Thorpe on the Hill Parish Council IP Ref: [REDACTED]

Mitigation of the proposed FGE Solar Farm on the “Stepping Out” (SO) routes in Thorpe on the Hill

Figure 3-2A SHEET 1

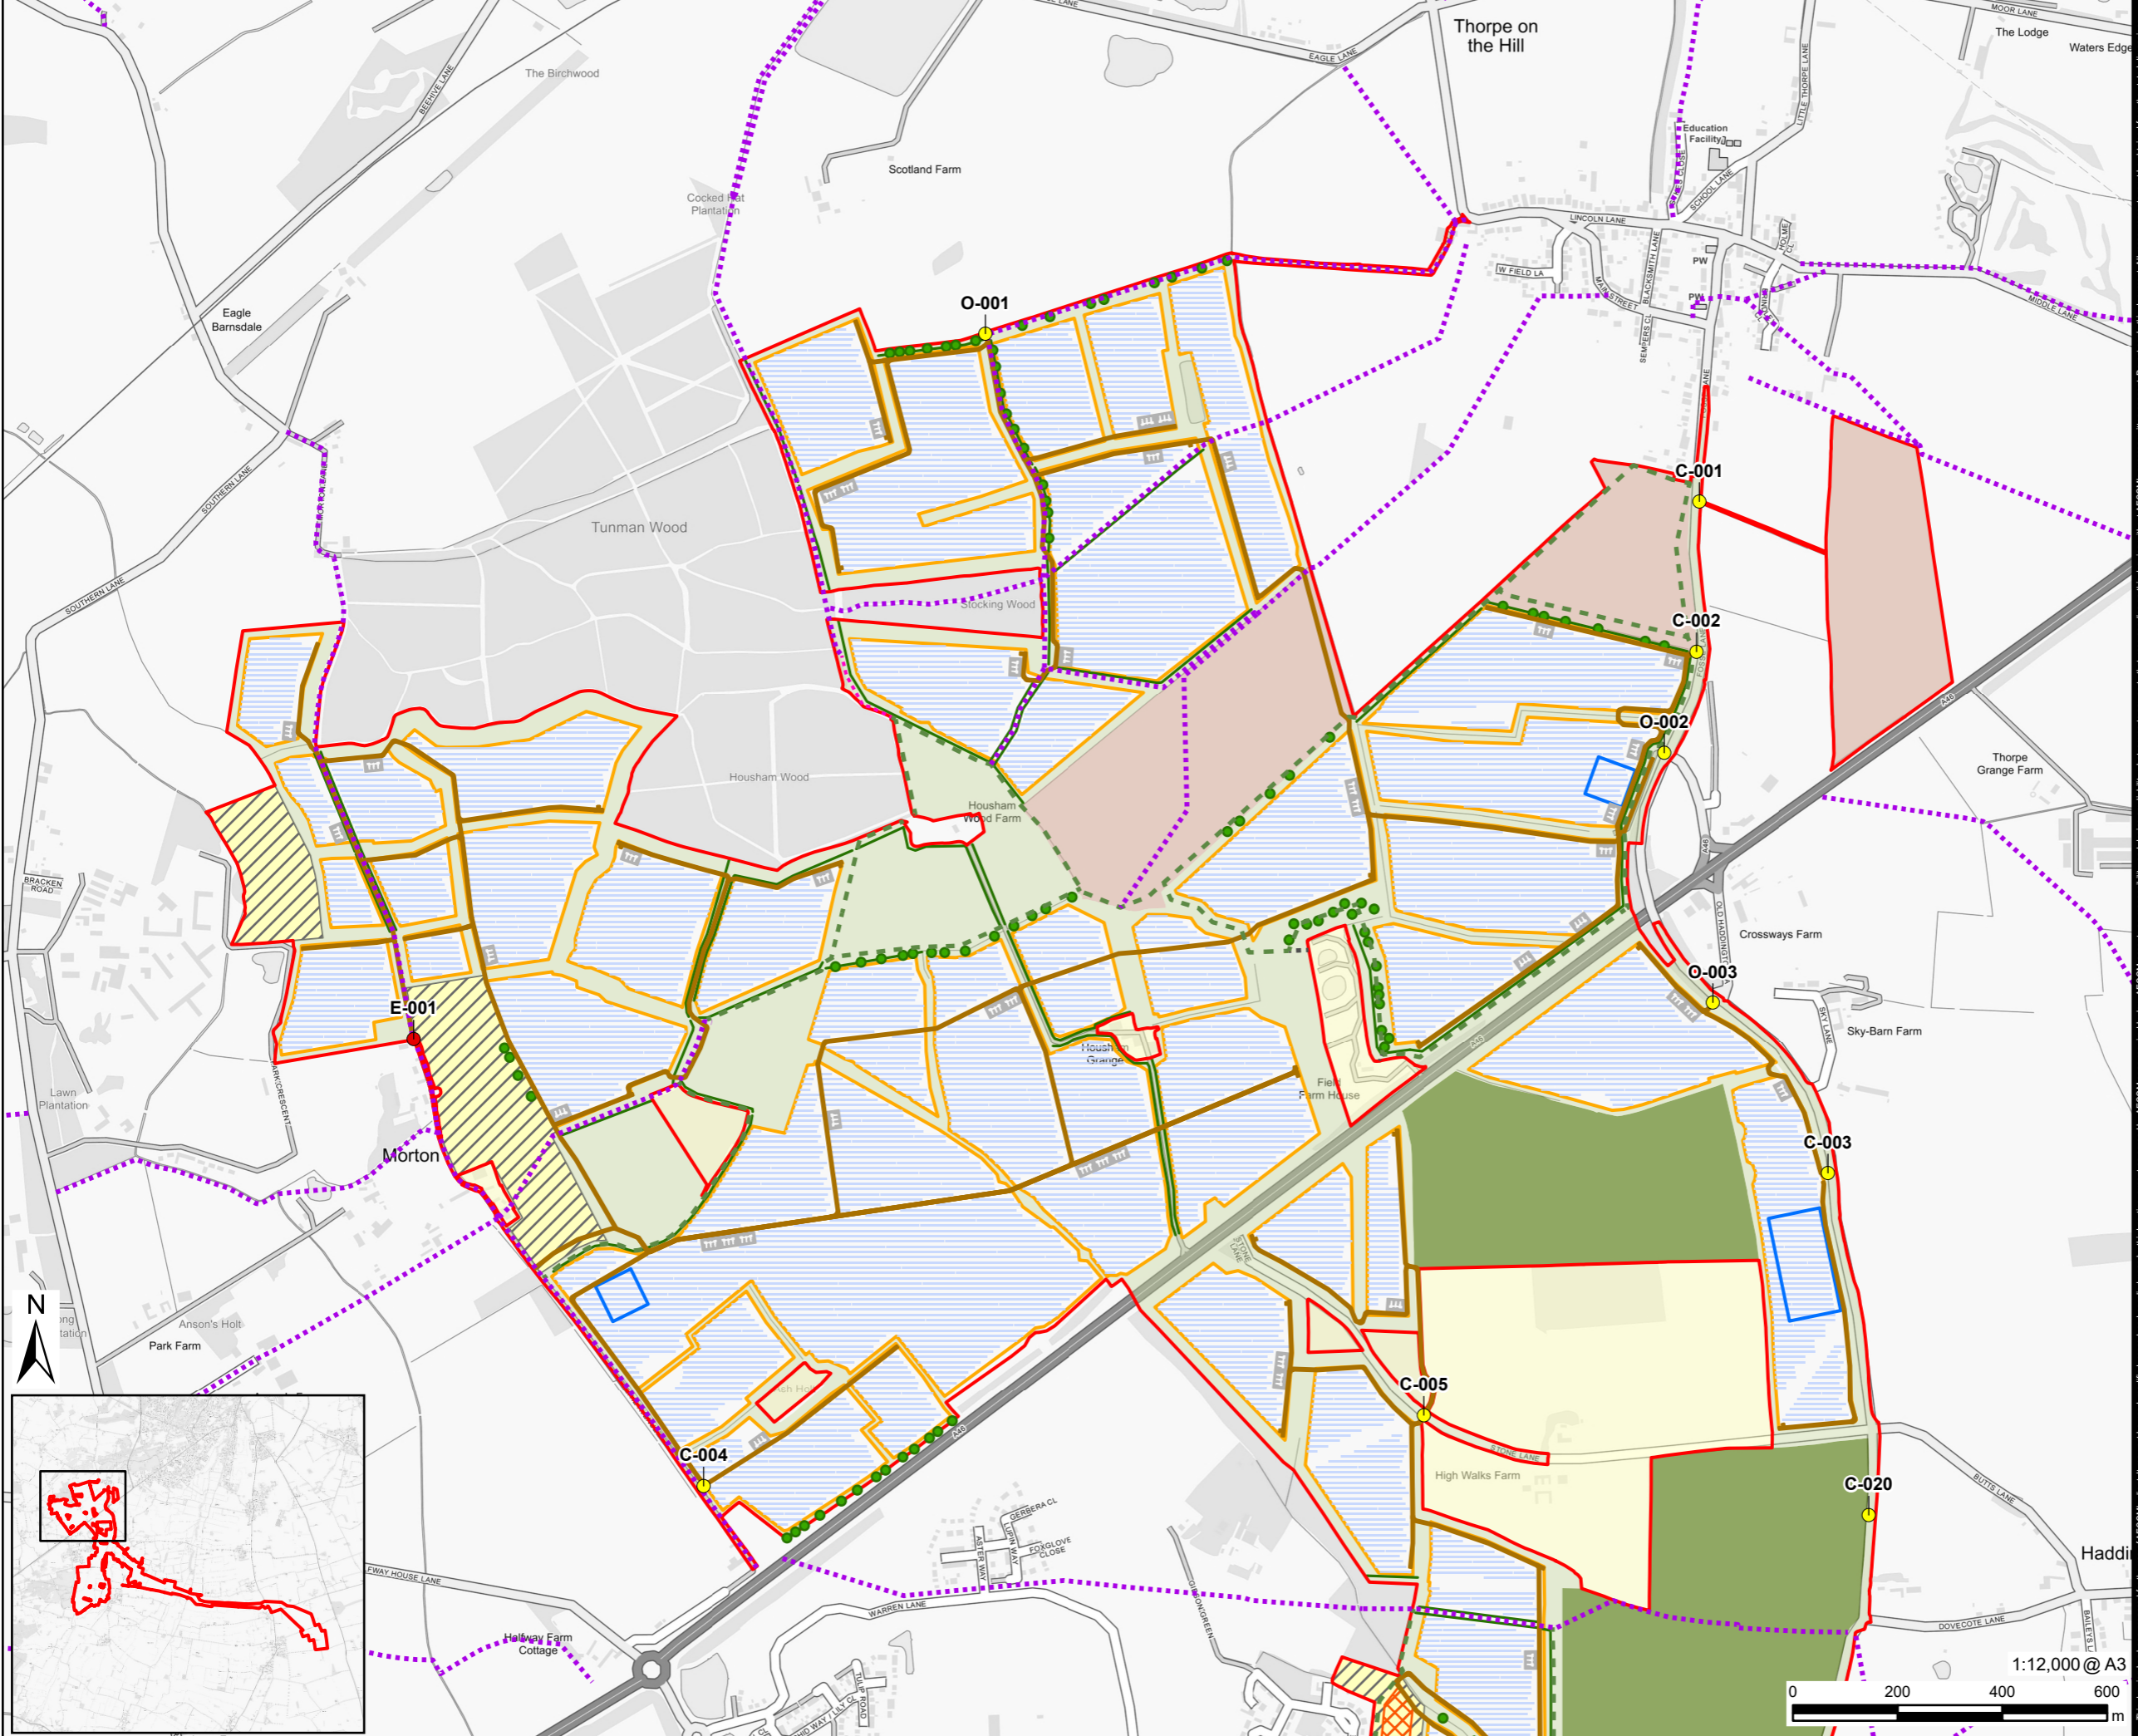
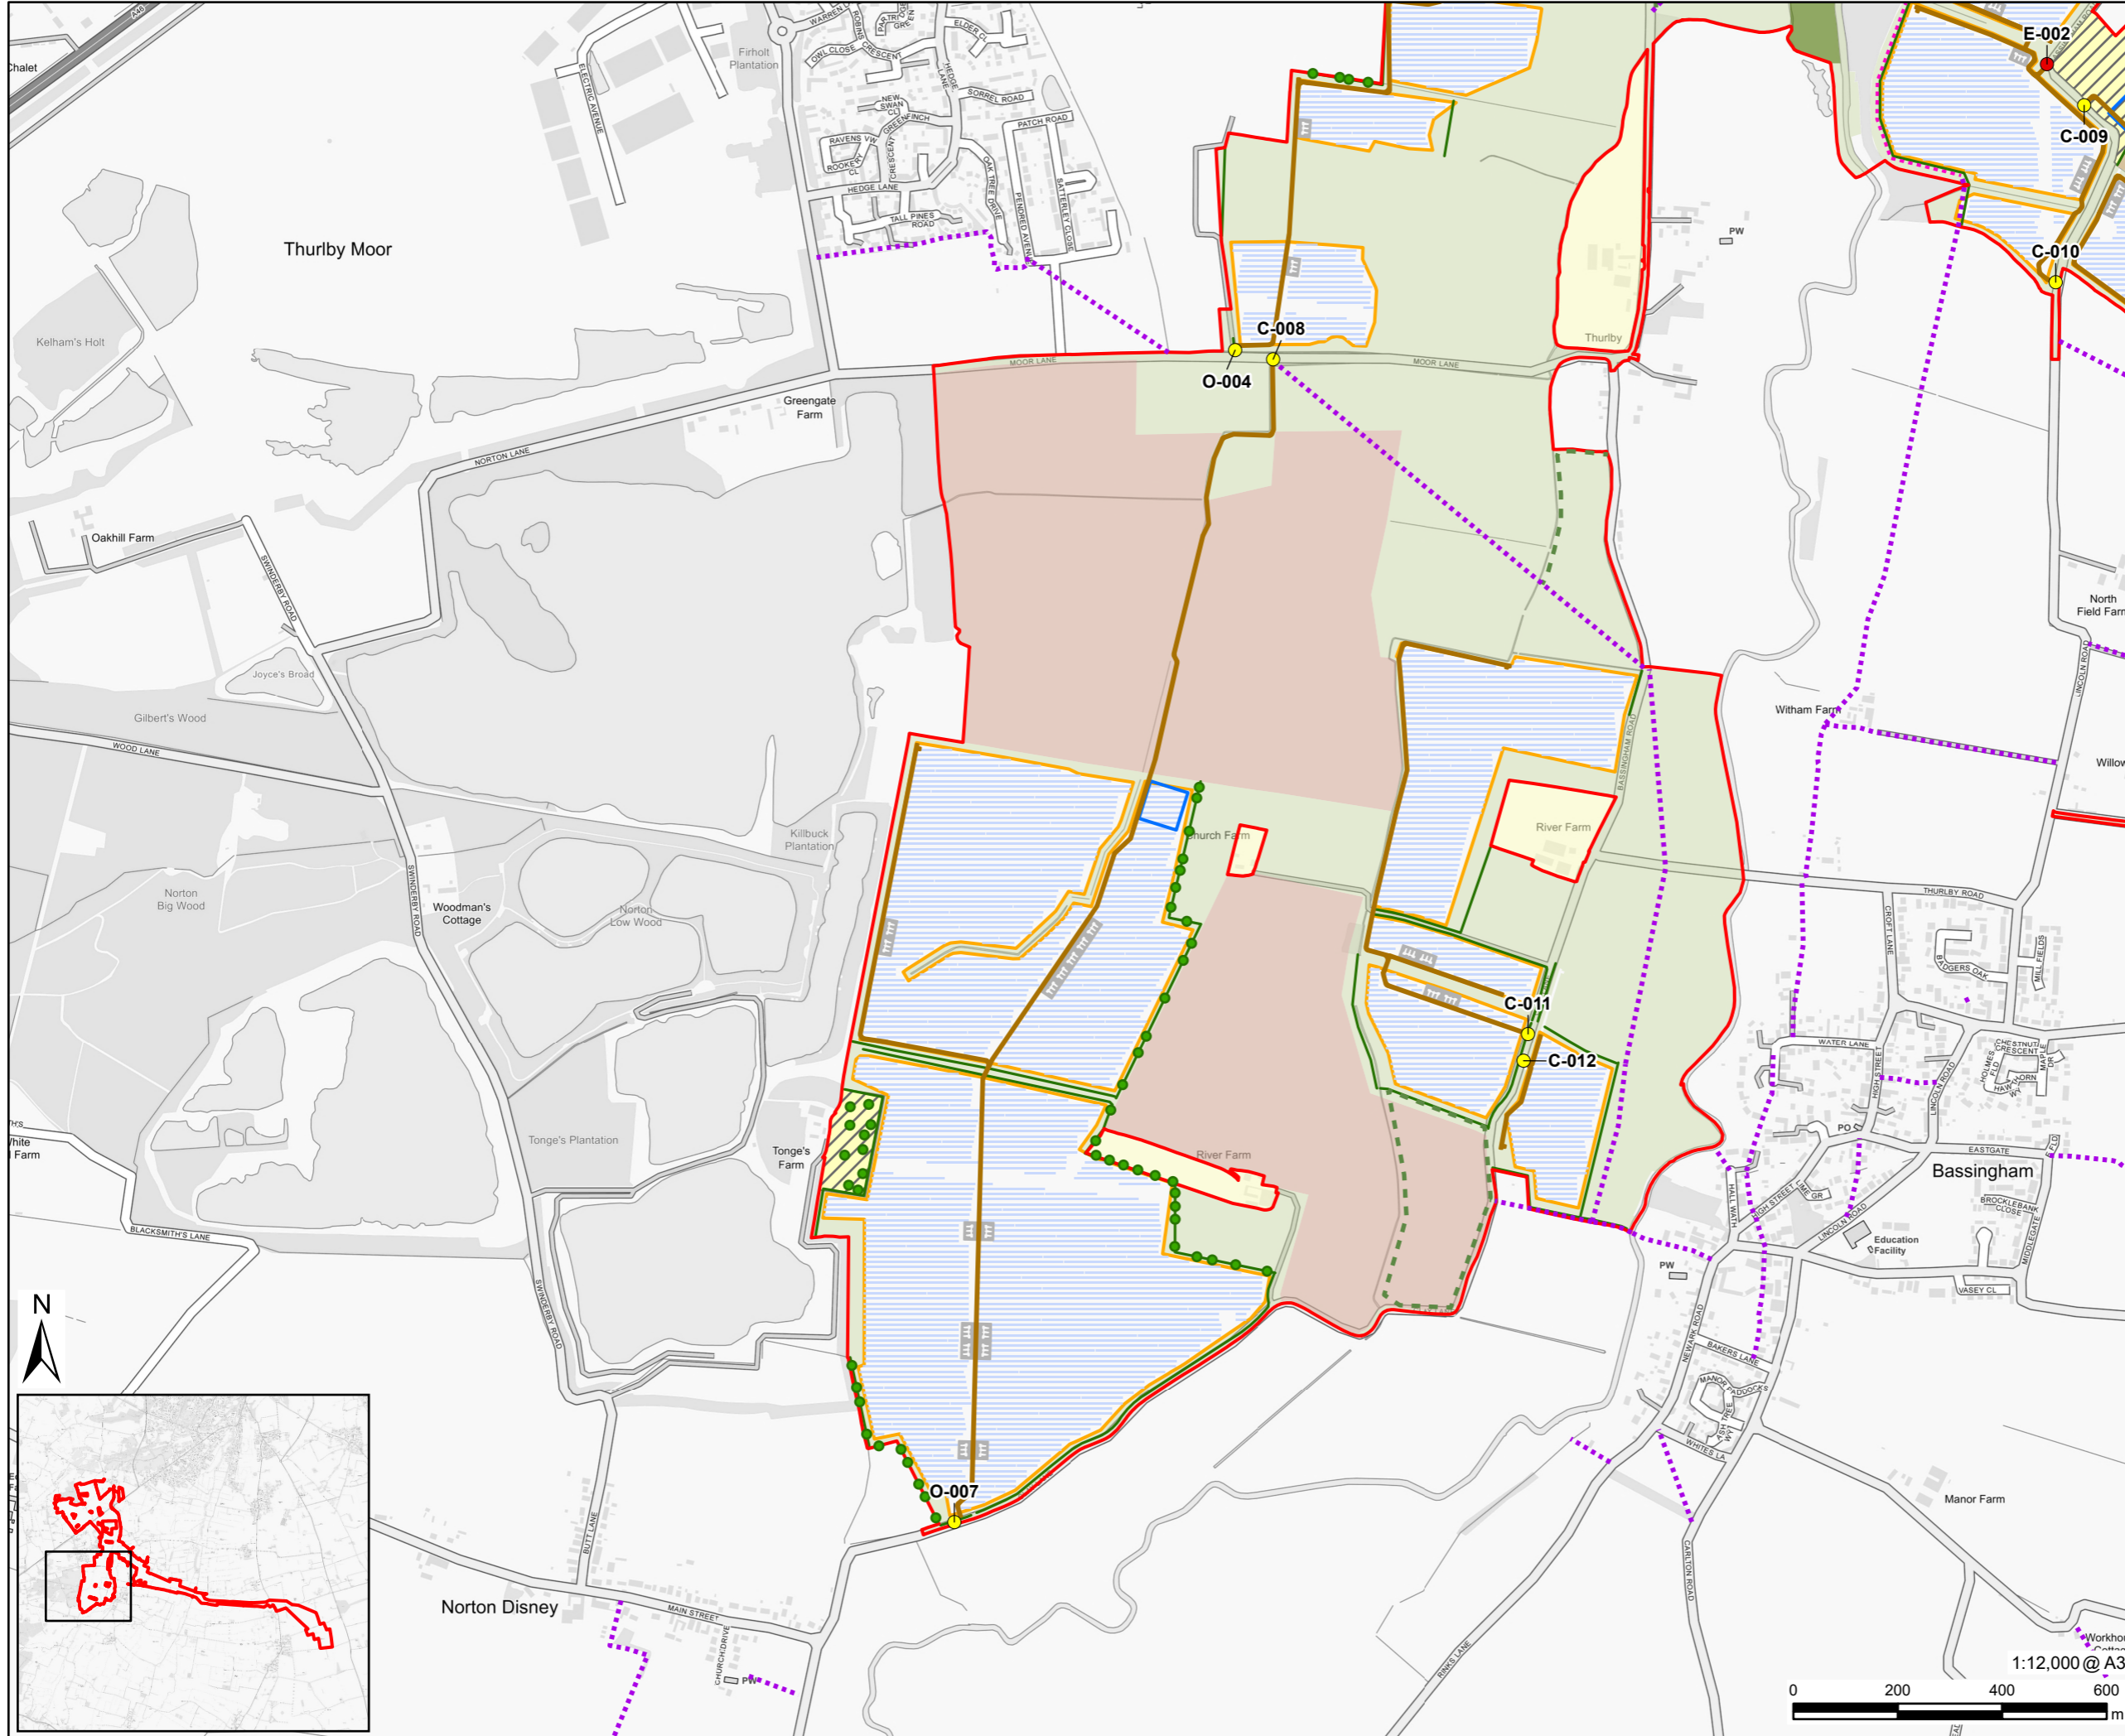
However, there remain areas of the layout which do not meet the criteria suggested by the PC. These features are illustrated in page 4 and are annotated accordingly because they specifically:

- Contain corridors where the routes will pass through solar arrays on both sides of the path
- Damage key open views from Stocking Wood to the village and vice versa

The PC continues to believe that a readjustment to the location of solar arrays in these areas could be implemented without greatly impacting the overall viability of the scheme. Consequently, the PC appeals to the Applicant to try and develop a revised scheme which addresses these important concerns, without resorting to inappropriate screening.
